Application No: FG/36/22/HH
Site Address: 166 Littlehampton Road Ferring BN12 6PH
Description of works: Two storey side extension, single storey front extension and new entrance and new vehicular access.

Thank you for your internet representation made on 29th March 2022 which has been recorded as an objection with the comments as follows:

Drawing Title:
Site Plan and Location Plan

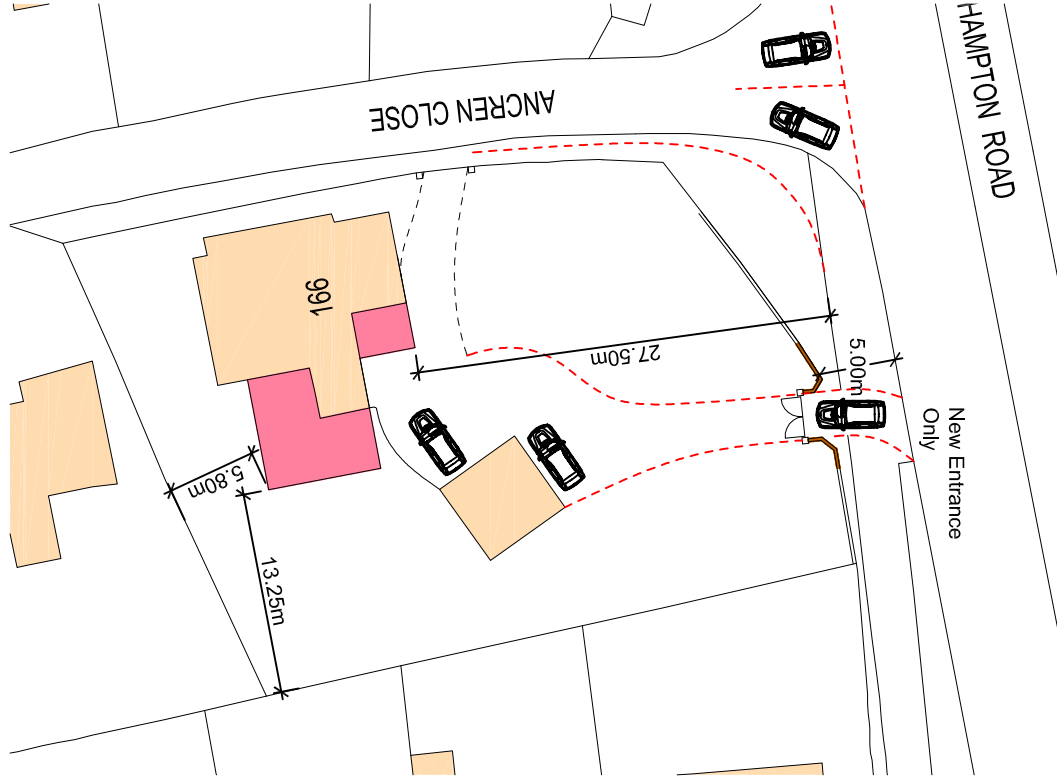
We refer to the surveyor's response that the splays requirement is invalid as the proposed new entrance is claimed to be for access only. However, there is no provision to restrict the use to access only. Unless adequate means to prevent this being used for egress are incorporated into the design proposal and made conditional, highway safety should not be compromised and the appropriate splays should be enforced. Ferring Parish Council are therefore obliged to object to this application pending satisfactory provisions to prevent egress from the proposed new access point.
